Subject: Geotechnical Investigation Program for 301 Palladium Drive, Ottawa Ontario  
Report Amendment #1

*DST File No.: IN-SO-021872*

Based on your e-mail dated February 16, 2016, regarding the City of Ottawa comments, DST Consulting Engineers Inc. (DST) has prepared the following supplemental letter subsequent to the completion of the final report, titled, "Geotechnical Investigation Report - 301 Palladium Drive Ottawa Ontario", DST File No.: IN-SO-021872, dated October 2015. DST's responses to the City of Ottawa comments are provided below.

drawing no.  
SSG-1

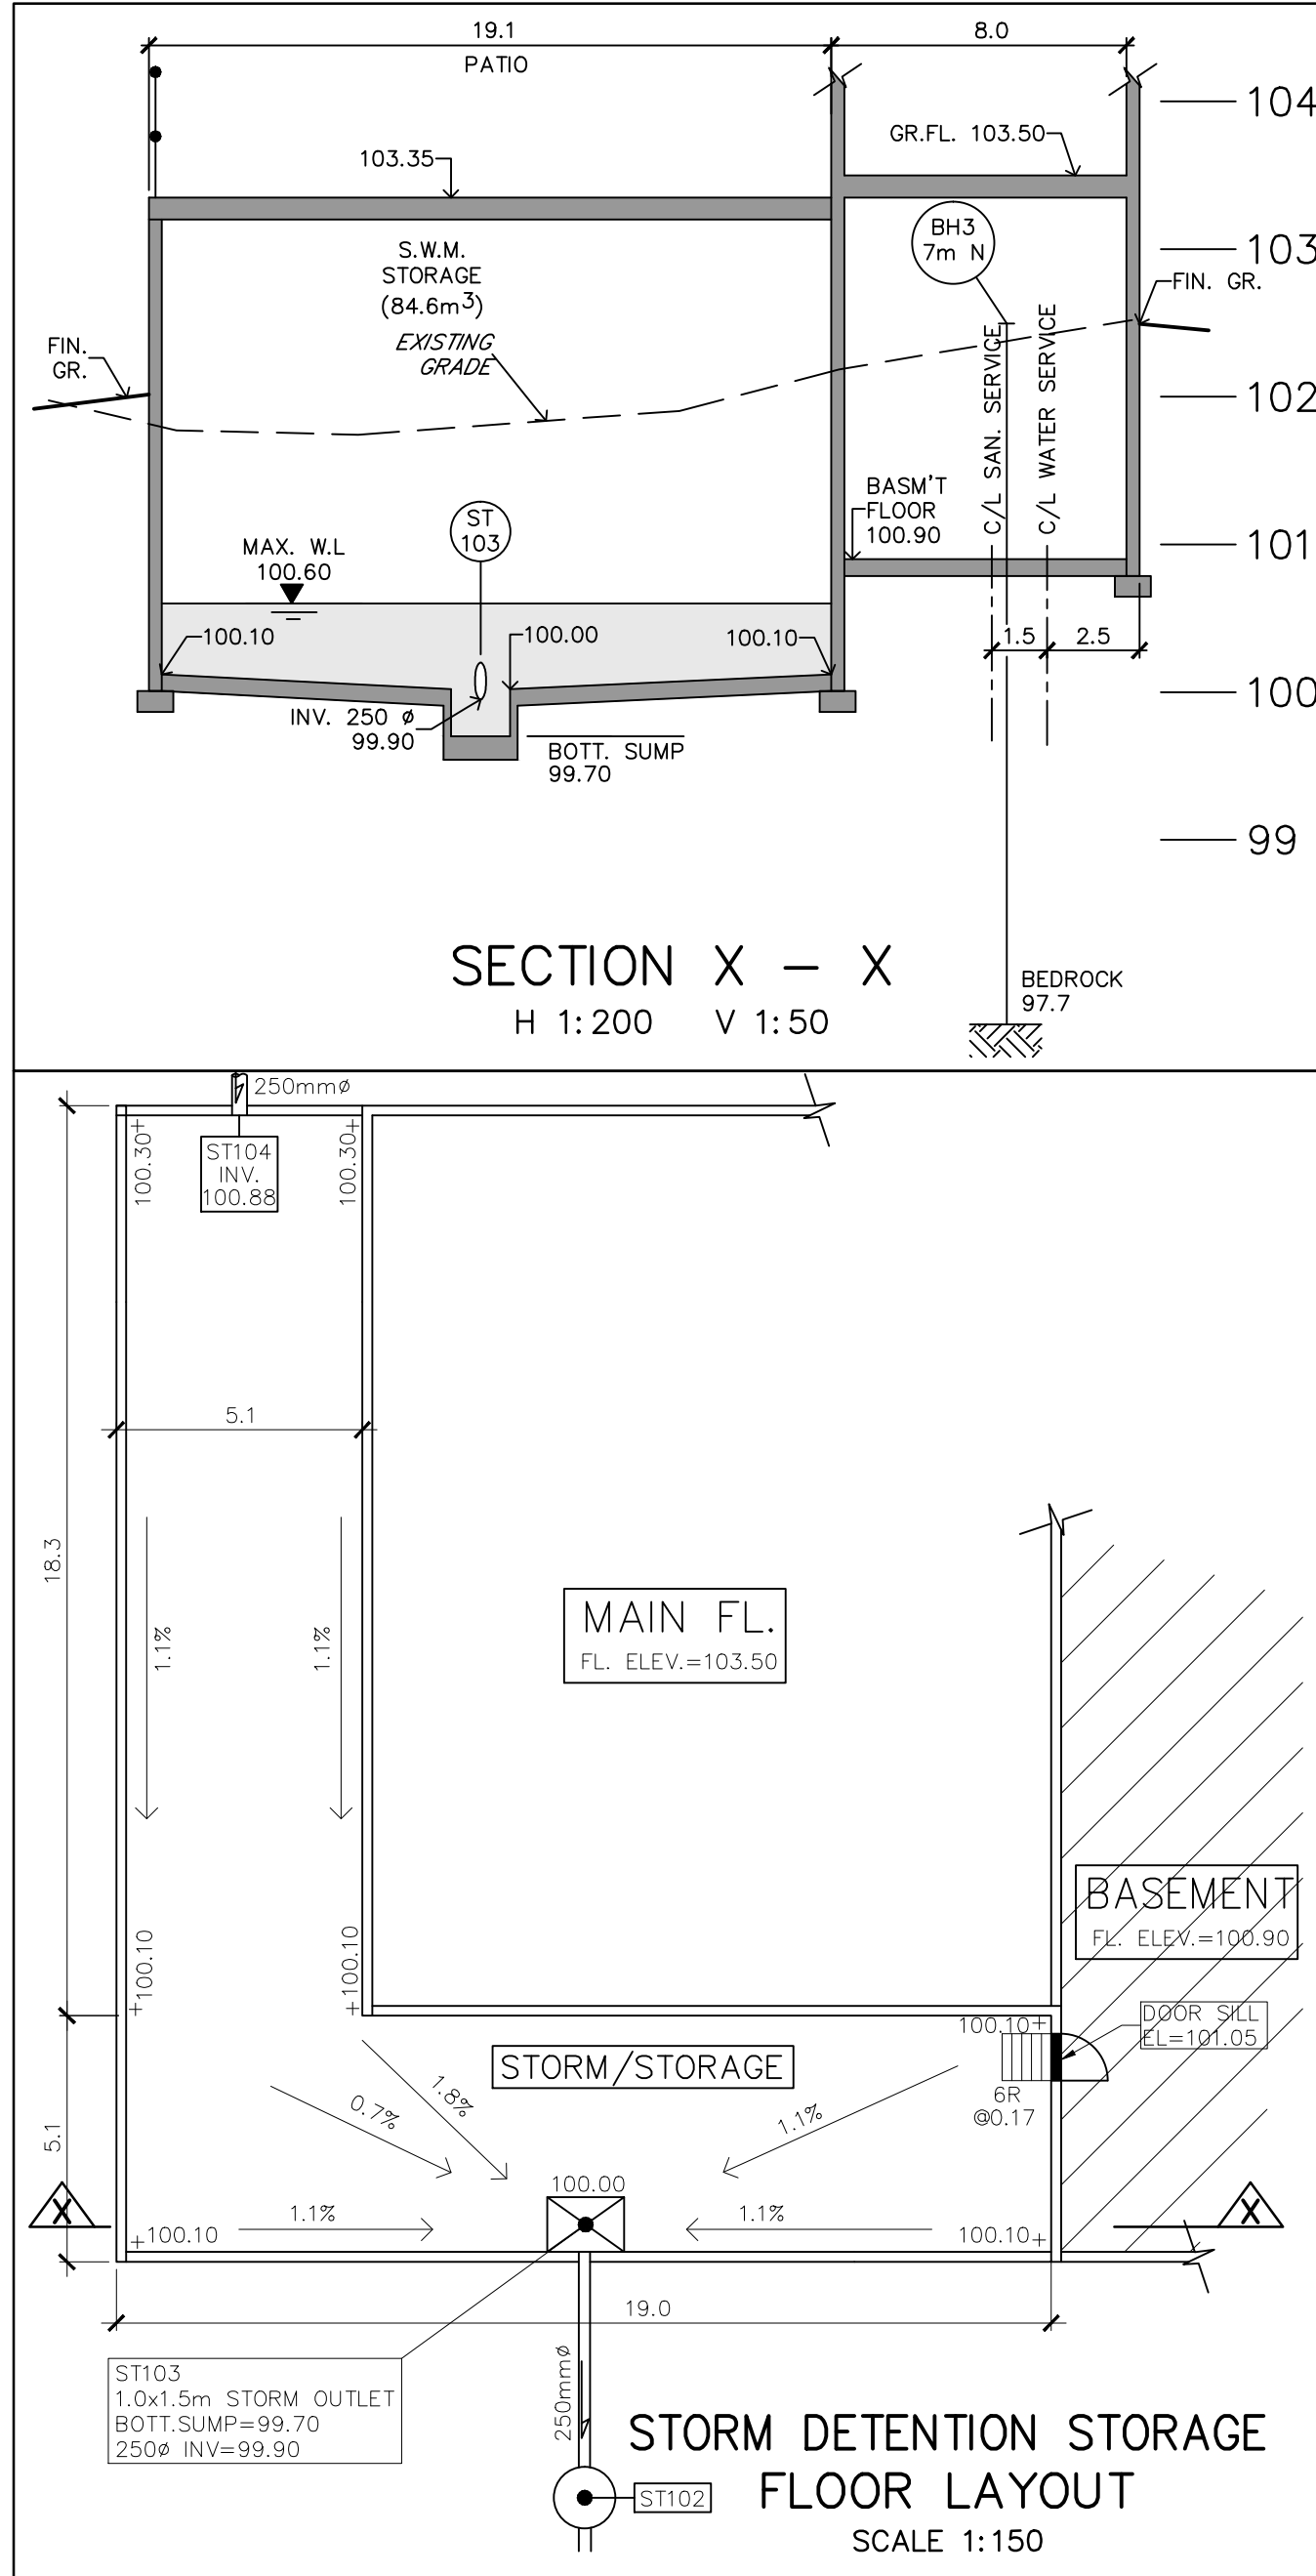
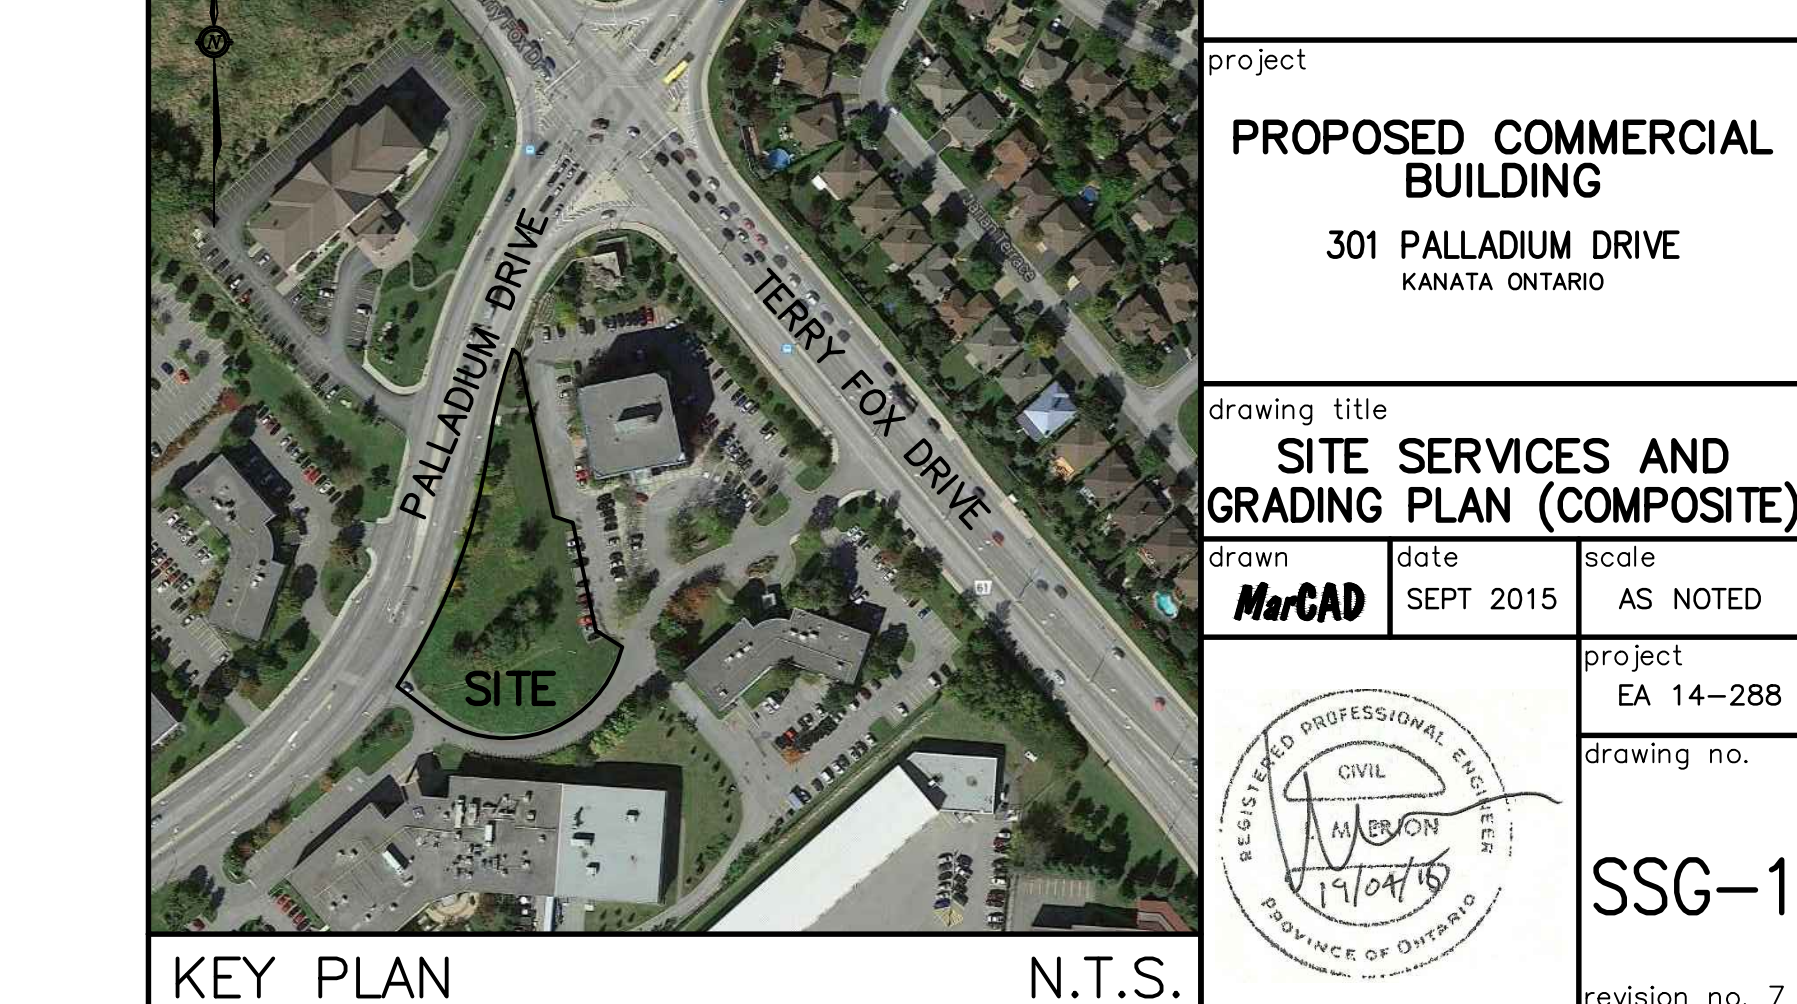
Please note that DST Consulting Engineers Inc. is required to submit a letter to the City of Ottawa signing off on the Grading Plan prepared by Erion Associates to verify that DST Consulting Engineers Inc. has reviewed the proposed grading and accepts that the grading is in conformance with the recommendations of the Geotechnical Investigation Report.

DST has reviewed all the drawings submitted by Erion Associates related to the grading and servicing plan for the proposed commercial building at 301 Palladium Drive. Based on our records, DST has completed the geotechnical investigation program using the following drawings:

Based on DST’s review of both drawings, the grading and servicing shown in the drawing of March 7, 2016, is in conformance with the recommendations of the Geotechnical Investigation Report.

Figure No.: **FIGURE 2**

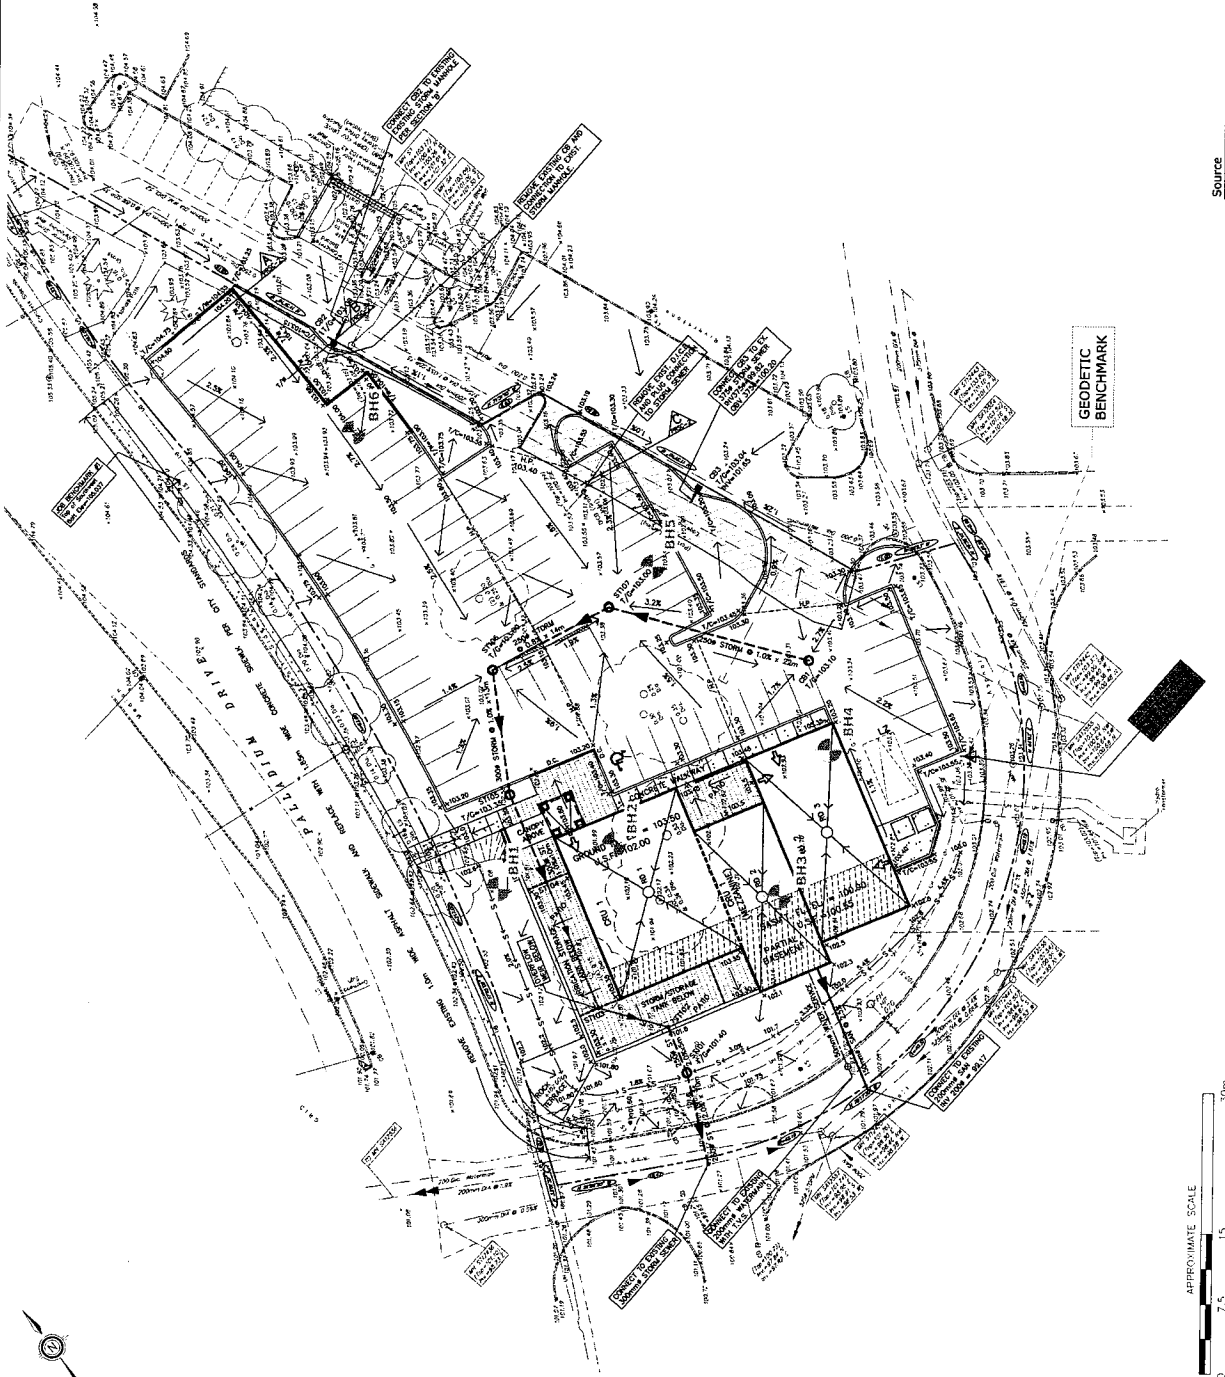
Please provide discussion in the report regarding the borehole configuration shown on the Borehole Location Plan.

It is indicated in section 4 (Scope of Services), of the Geotechnical Investigation Report - 301 Palladium Drive Ottawa Ontario", DST File No.: IN-SO-021872, dated October, DST has completed the following scope of work to meet the project requirements:

- Placement of three (3) boreholes within the proposed building footprint (BH2, BH3 and BH4) and advanced to auger refusal depths on inferred bedrock and termination depth of 4.3 to 8.9 m. Bedrock was confirmed in Borehole BH3 by coring a 4.2 m length of bedrock. These boreholes provide information the geotechnical information for the building foundation and excavation works.
- Placement of three (3) boreholes (BH1, BH5 and BH6) within the proposed exterior of the building and parking lot area. The boreholes were advanced to depths ranging from 3.6 to 4.8 m. These boreholes provide the geotechnical information for the pavement design and excavation works.
- Installation of standpipe piezometer in four (4) boreholes for the monitoring of the groundwater levels. Locations of the advanced boreholes are shown in Appendix B of the report.
